Date: 23-Jun-2026
Our Ref: 2026/91192

**Application for a non-material amendment following a grant of planning permission,
Town and Country Planning Act 1990**

Non material amendment to previous permission 2024/91998 for erection of special educational needs and disabilities school (Use Class F1), comprising educational buildings, roof mounted photo-voltaic panels, sensory garden spaces, multi-use games areas, landscaping, hardstanding areas, carparking, access with secure fencing and associated ancillary development
Former, Almondbury High School, Fernside Avenue, Huddersfield, HD5 8PQ
Application Number: 2026/91192

TITLE
**GA ELEVATIONS
COURTYARD**

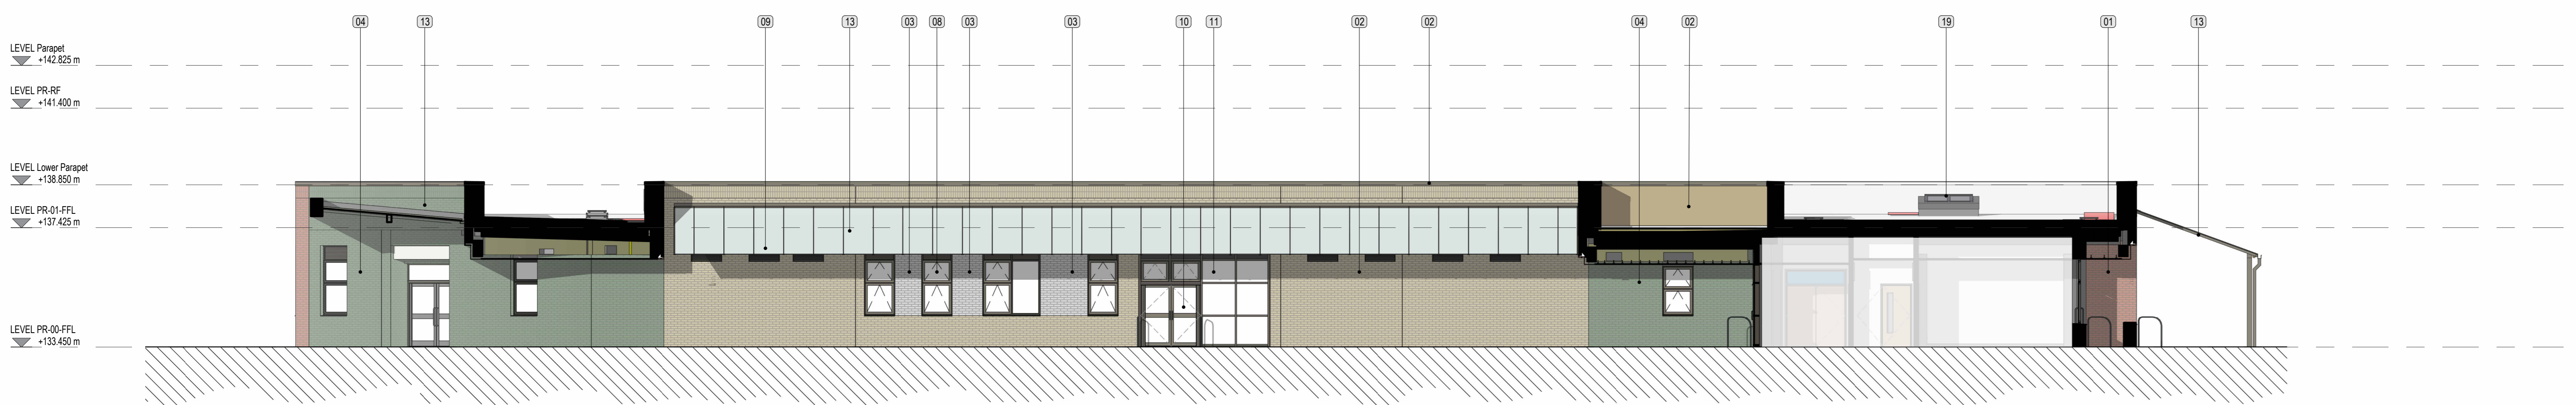
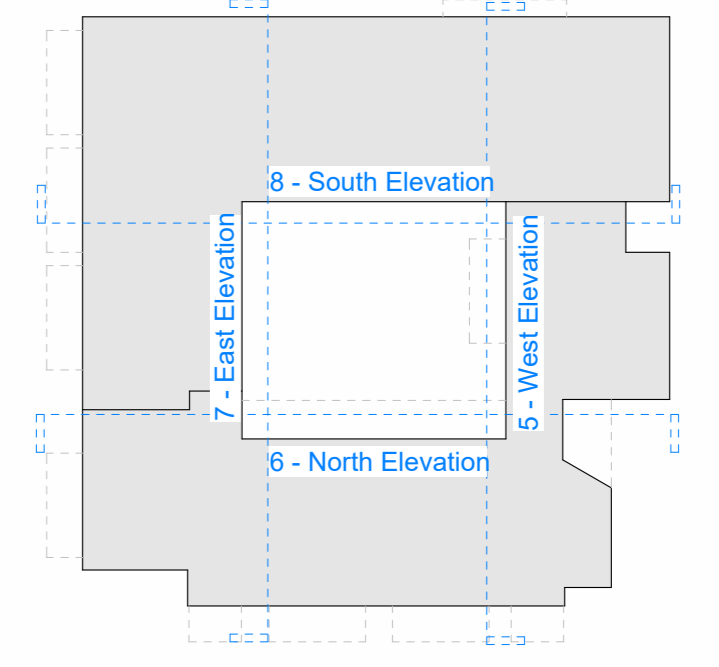
- General update to the window designs:
 - Head of windows and openings lowered by 150mm throughout.
 - Base of all windows lifted to +1050mm throughout (except wing), removing low level spandrel panel to some windows.
 - Removal of 'look-alike windows' within courtyard to maintain only louvre at head.
- Removal of glazed canopy and bridging brickwork parapet.
- Removal of sections of render and replacement with glazed brick in some locations.
- Changed layout to group room windows on western elevation and removal of external downpipes.
- Reduced depth of recesses to some entrance doors.
- A 15m² extension is proposed on the ground floor into the courtyard area.

TITLE
EXTERNAL LIGHTING SHEET 1 OF 2

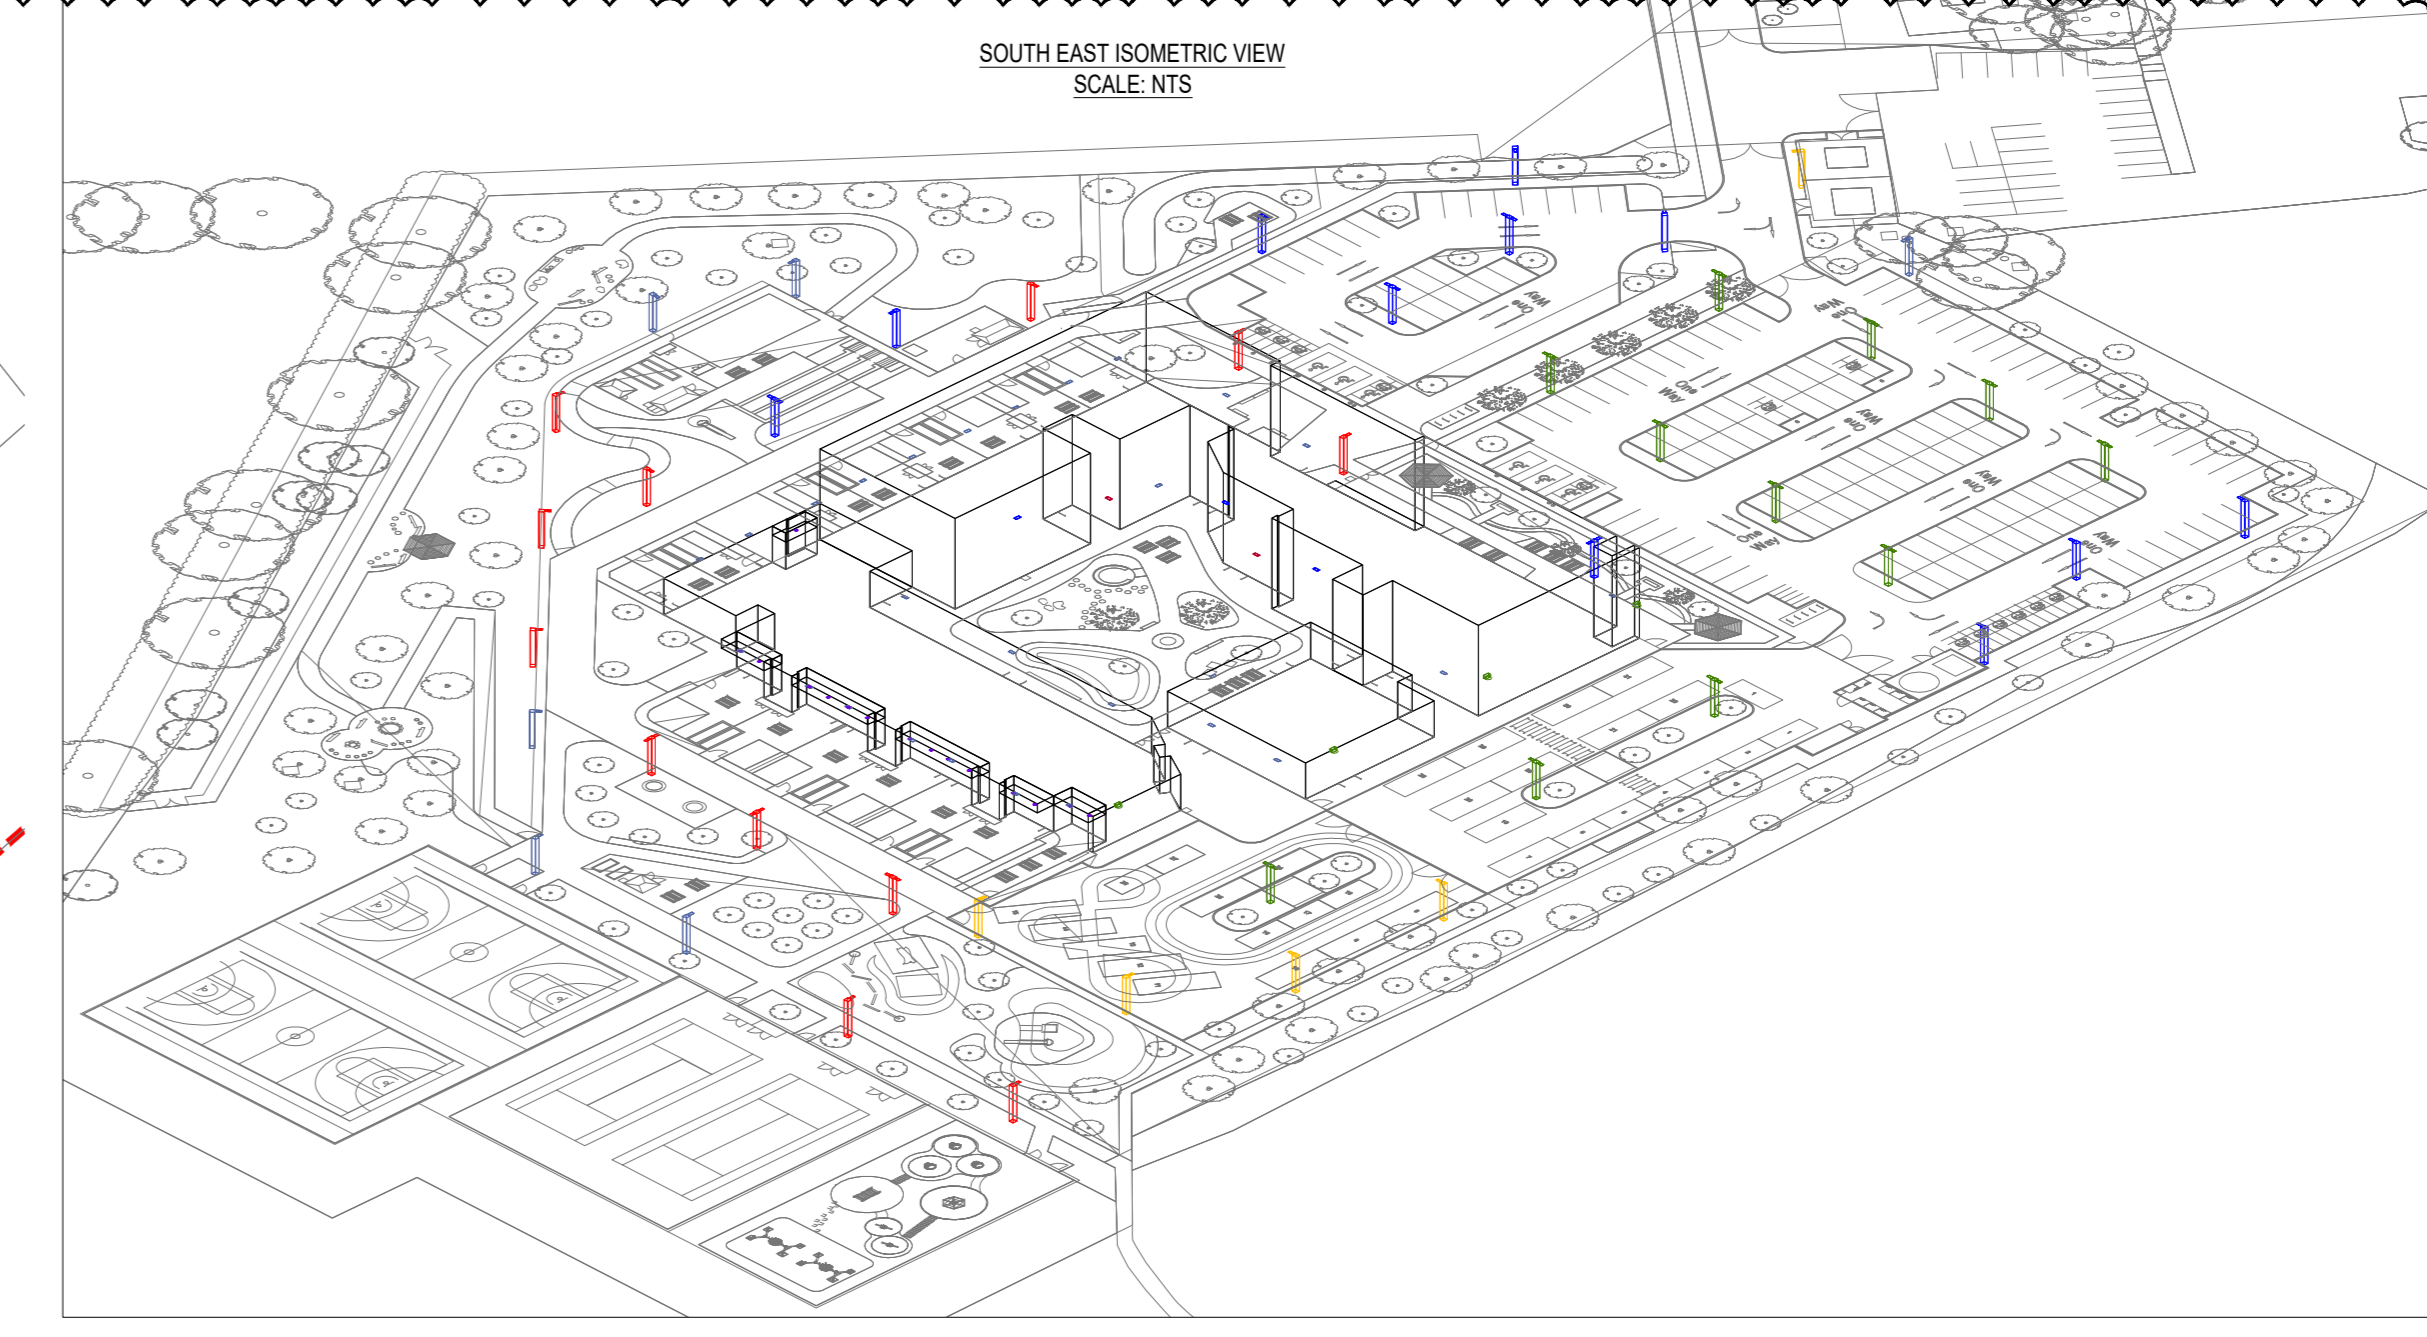
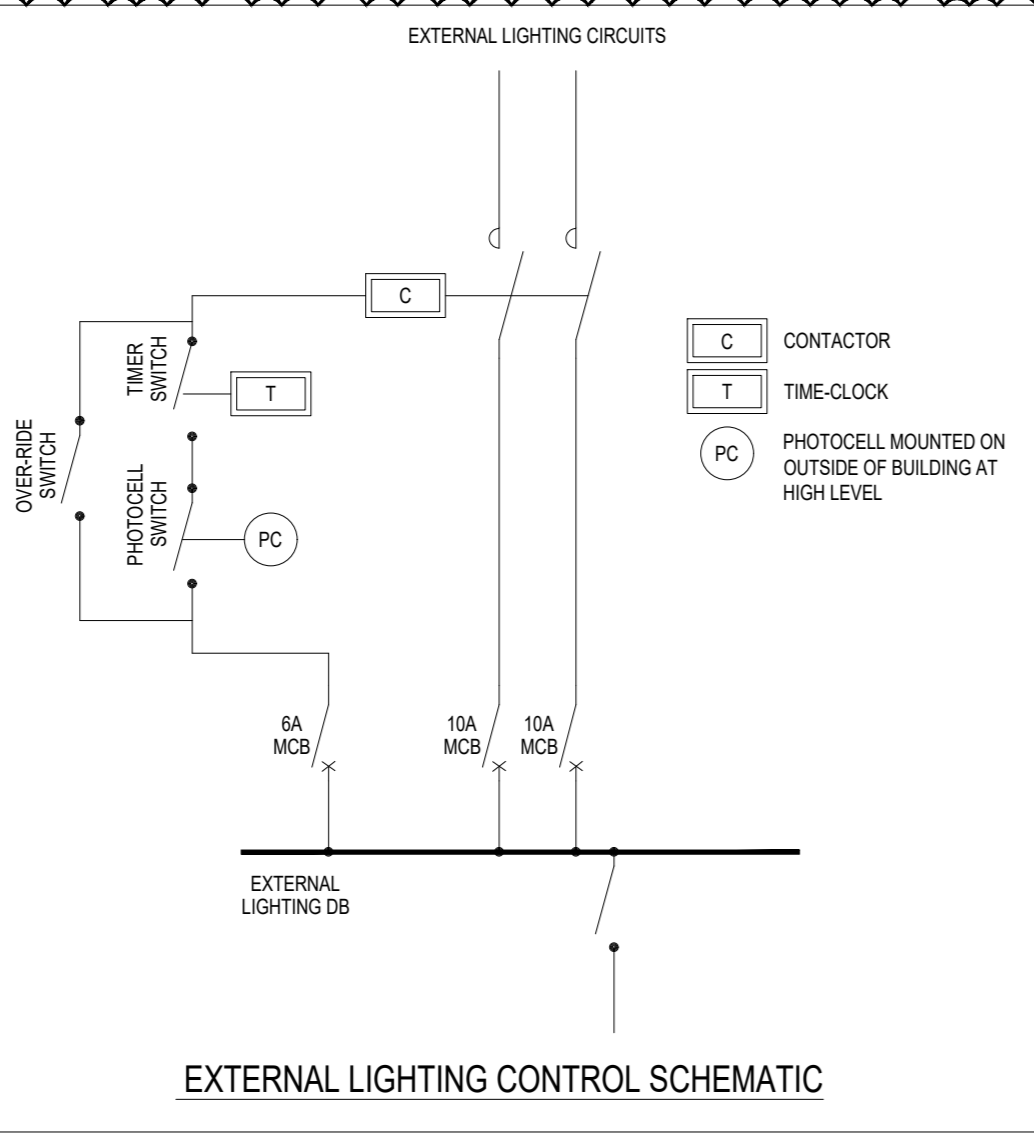
- Whilst the specification of the lighting remains unchanged, an updated lighting drawing has been prepared to reflect changes following Stage 4 Design.

20. The external lighting for the play area shown on hereby approved drawing no. NWSC-GAH-00-00-D-E-01101-External Lighting Sheet 1 of 2-S3-P03 & NWSC-GAH-00-00-D-E-01102-External Lighting Sheet 2 of 2-S3-P03, and any external lighting erected for the MUGA's, shall only be operated between –
